+WELWYN HATFIELD BOROUGH COUNCIL – DEVELOPMENT MANAGEMENT
DELEGATED REPORT

APPLICATION No: 6/2015/1887/HOUSE

SITE ADDRESS: 387 St Albans Road West, Hatfield, AL10 9RU

DESCRIPTION OF DEVELOPMENT: Erection of single storey rear and two storey front and side extension

PROPOSED FIRST FLOOR Scale :- 1 : 50

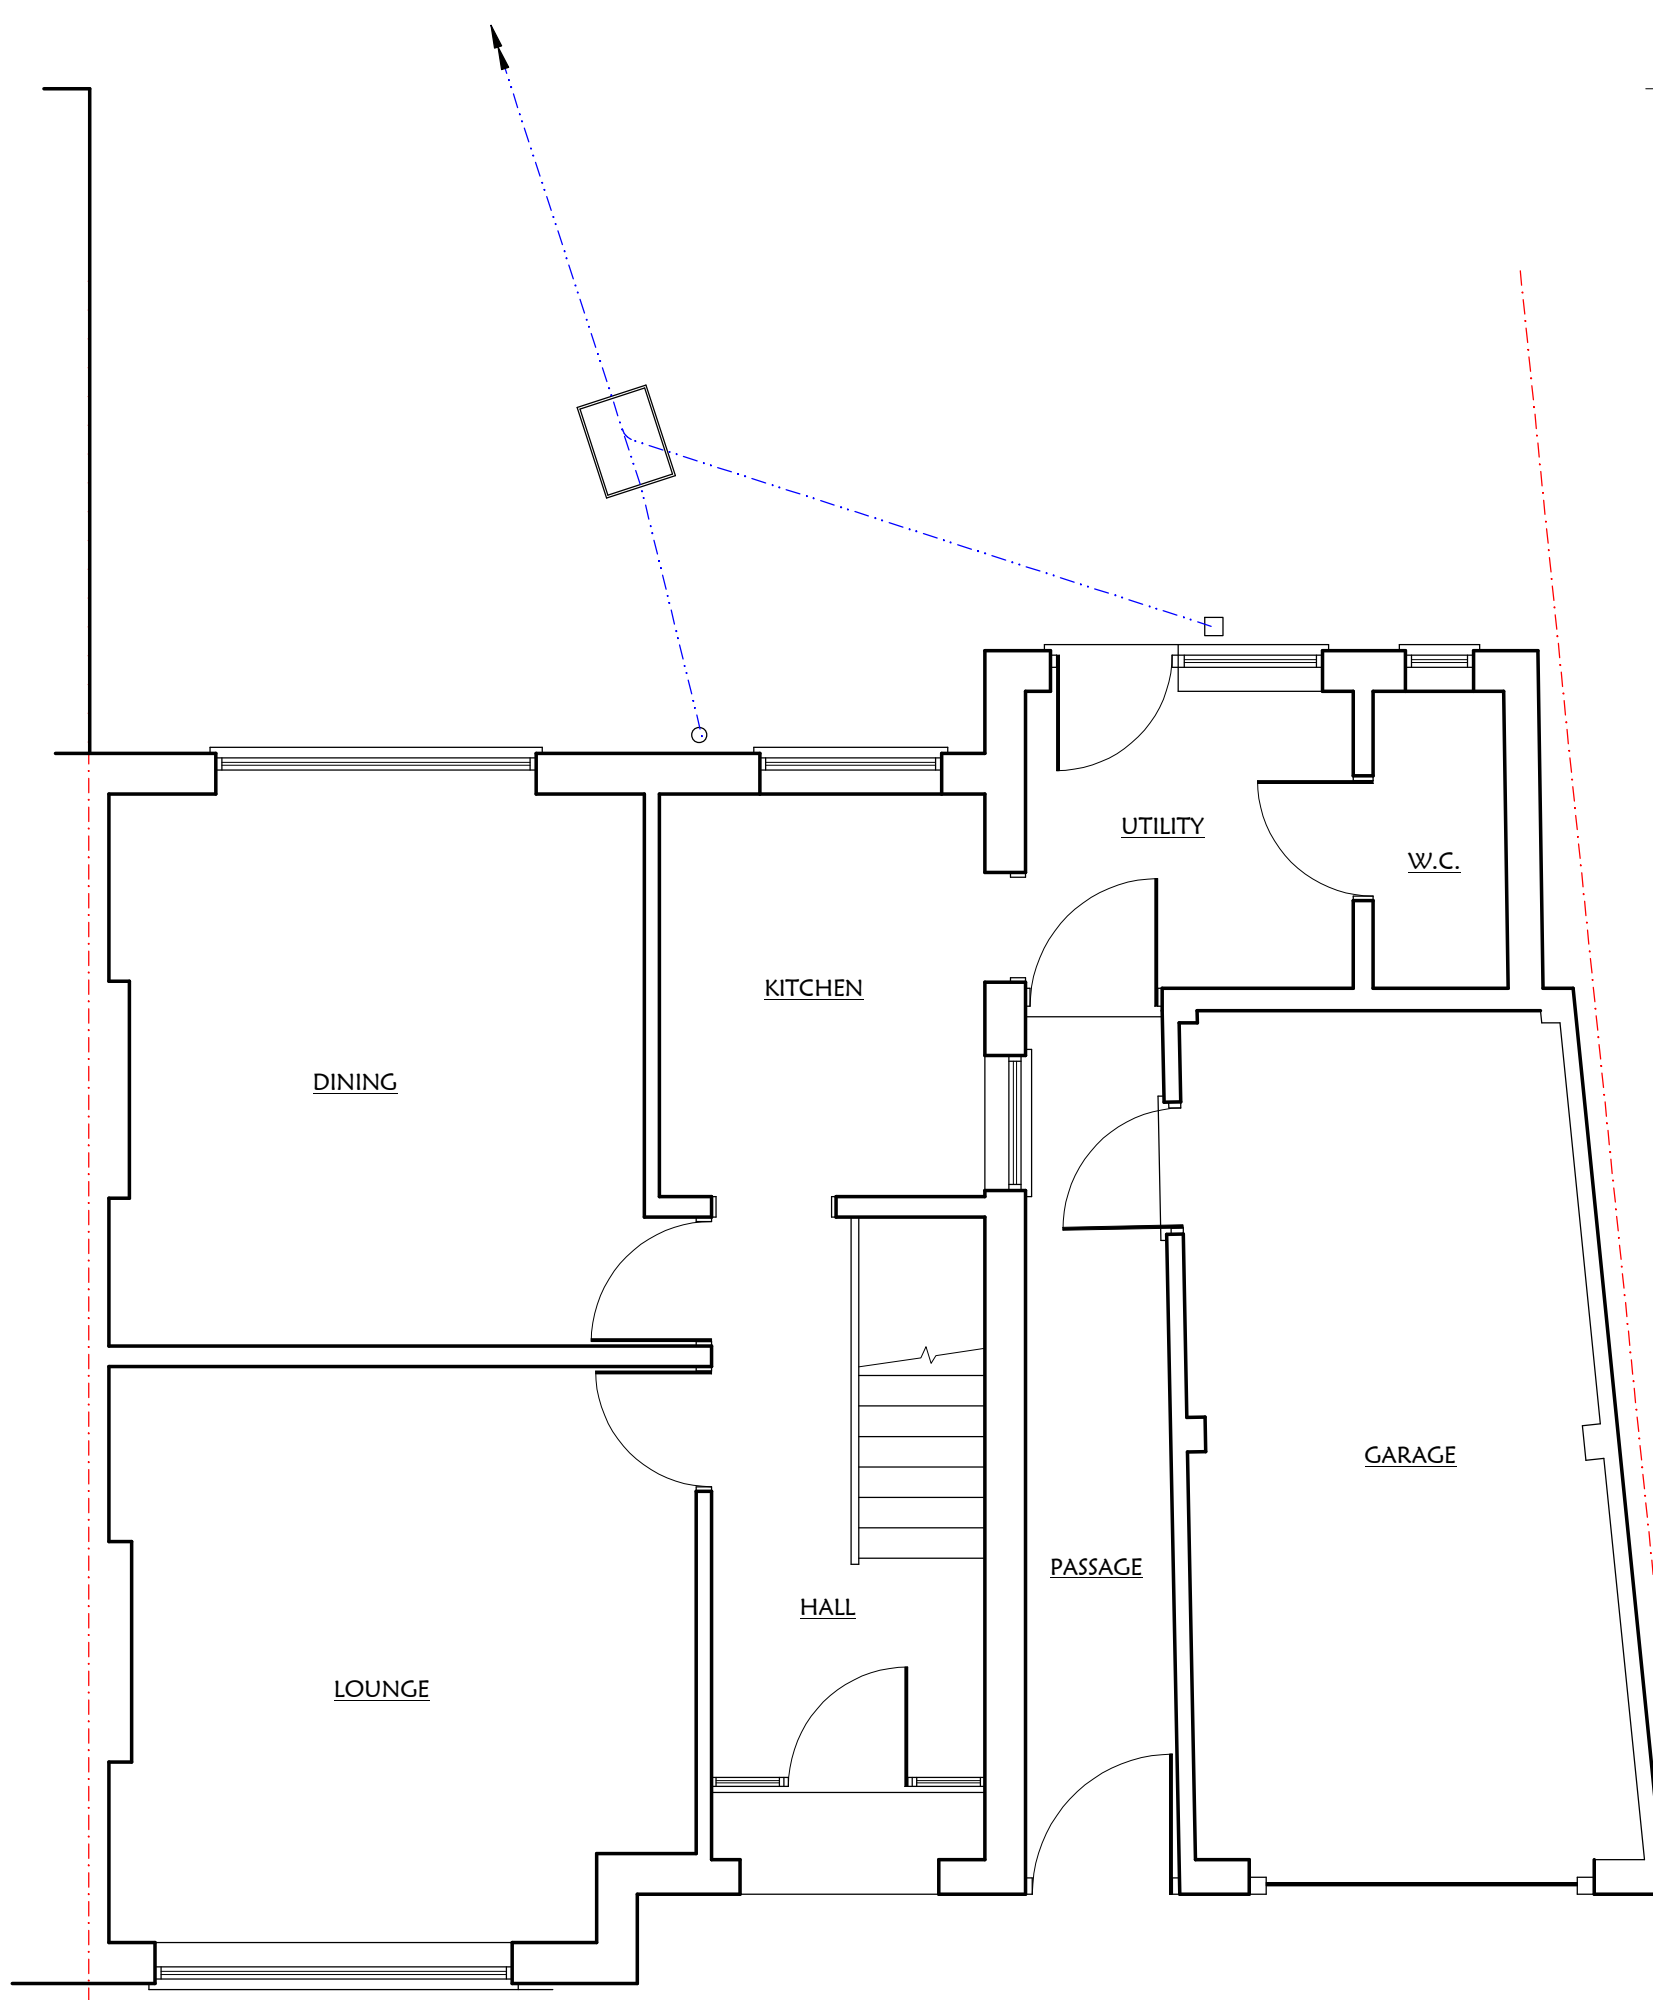
In this instance, the first floor of the proposed two storey side extension is to be set in between 1.25m - 1.12m from the west boundary of the dwellinghouse which is considered sufficient to ensure that no 'terracing' effect is created. The width of the first floor side extension at 3.14m would be only marginally greater than half the width of the main dwellinghouse at 6.0m and considered acceptable as a proportionate addition to the dwellinghouse. As such, the proposed first floor is considered of an acceptable design, scale and bulk in relation to the original dwellinghouse.

PROPOSED GROUND FLOOR Scale :- 1 : 50

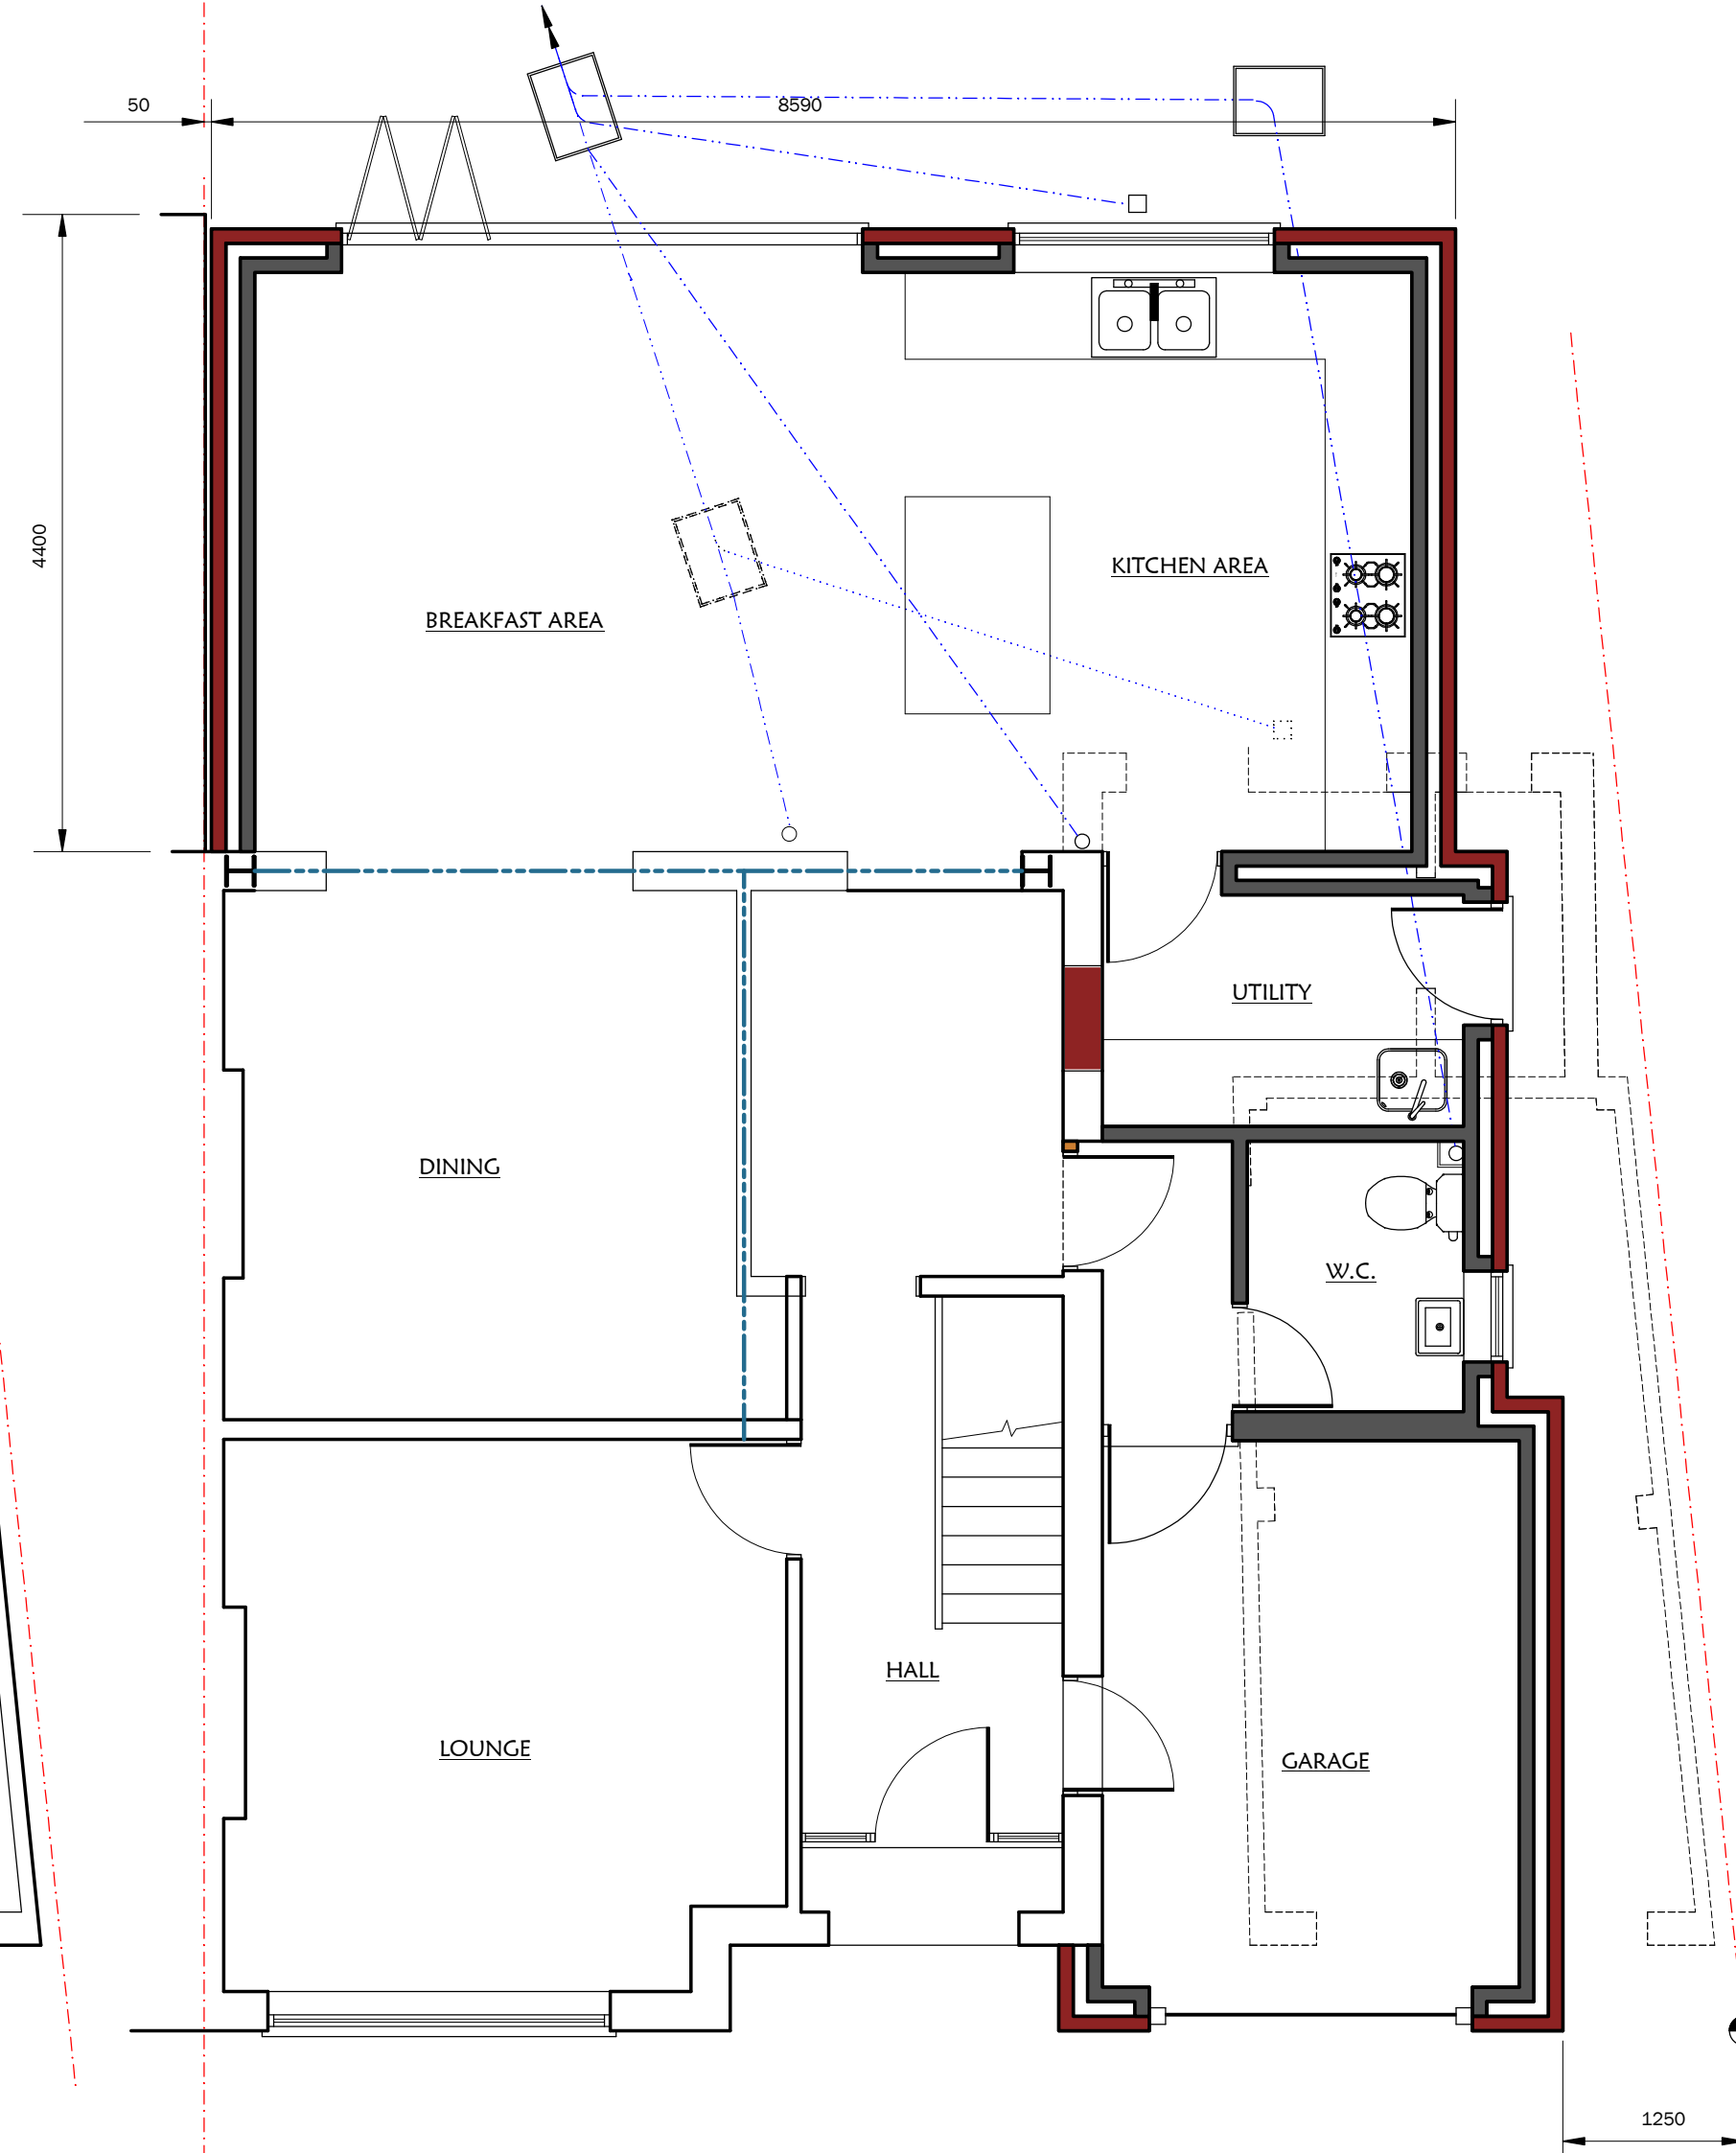
The proposed single storey rear extension is to be built up to the east boundary adjoining no. 385 which as a rear extension. The west flank of the proposed single storey rear extension is set in at its most narrowest point to the boundary with no. 389, 0.7m widening to 1.1m and at a depth of 4.4m, a ridge height of 3.3m and eaves height of 2.43m comply with the guidance contained in the Residential Design Guide SDG and considered of a size, scale and form that would respect the character and appearance of the dwelling to be extended and the surrounding area.
